Our ref: R/255/09/NMA
Your ref:

14 January 2009

Application for a non-material amendment following grant of planning permission R/49/09 to add Marley Contour vent tiles and Velux sun tunnel entries; 8 Bushby Avenue, Rustington.

Plan View

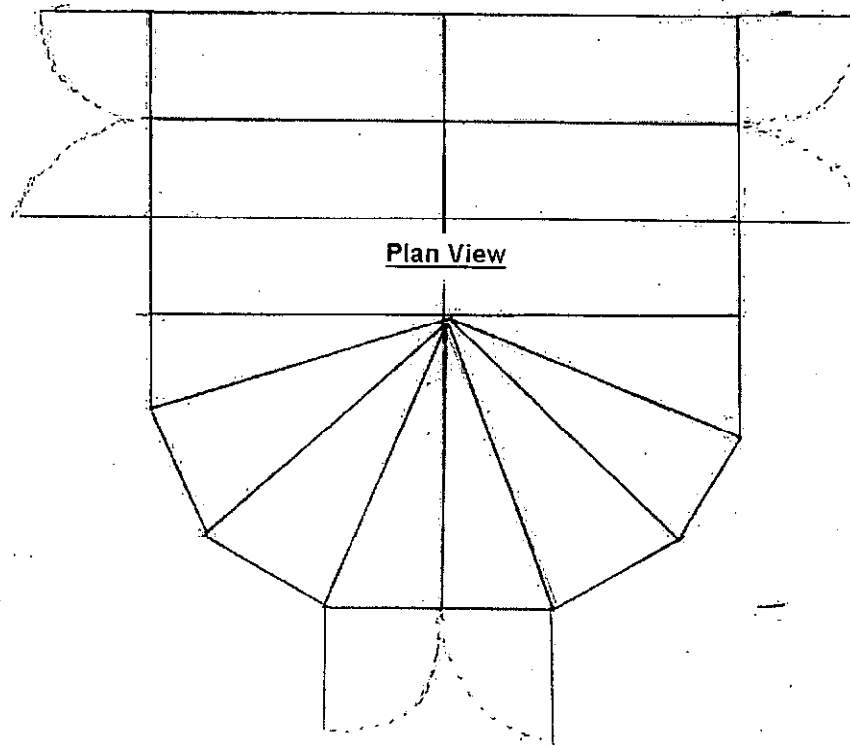
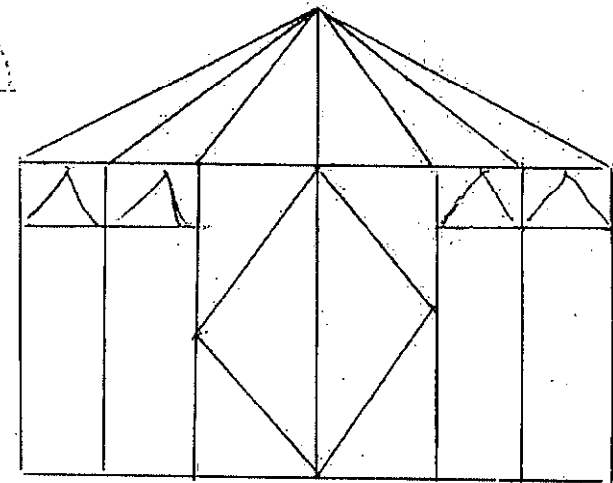
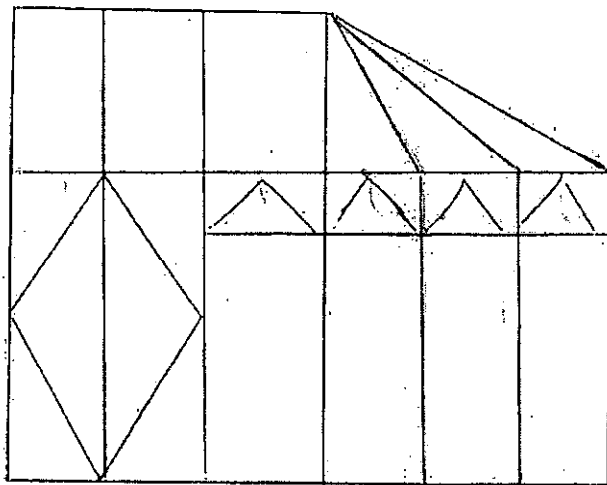
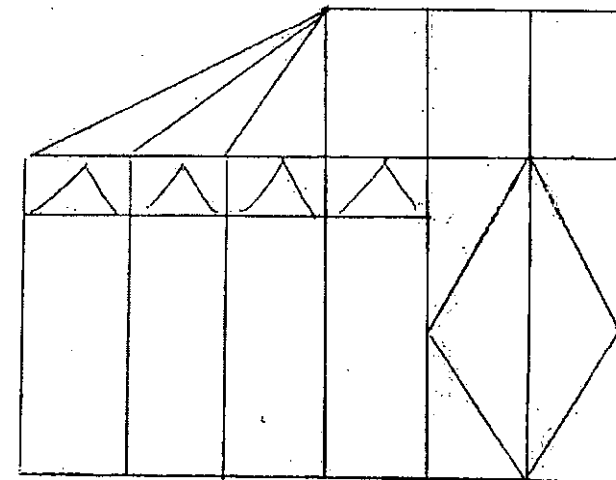
The changes identified from the approved plan namely the inclusion of Marley Contour vent tiles and sun tunnel entries. 3no. Marley Contour vent tiles within the east and west roof elevations, 2No. vent tiles within the rear roof elevation and 1No. sun tunnel entries within the side roof elevations and 2No. sun tunnel entries within the rear elevation will be acceptable as Non Material Minor Amendments.

Please note that the Proposed Minor Build Revision plans dated 24th Nov 2009 therefore become the approved plans for planning application R/49/09.
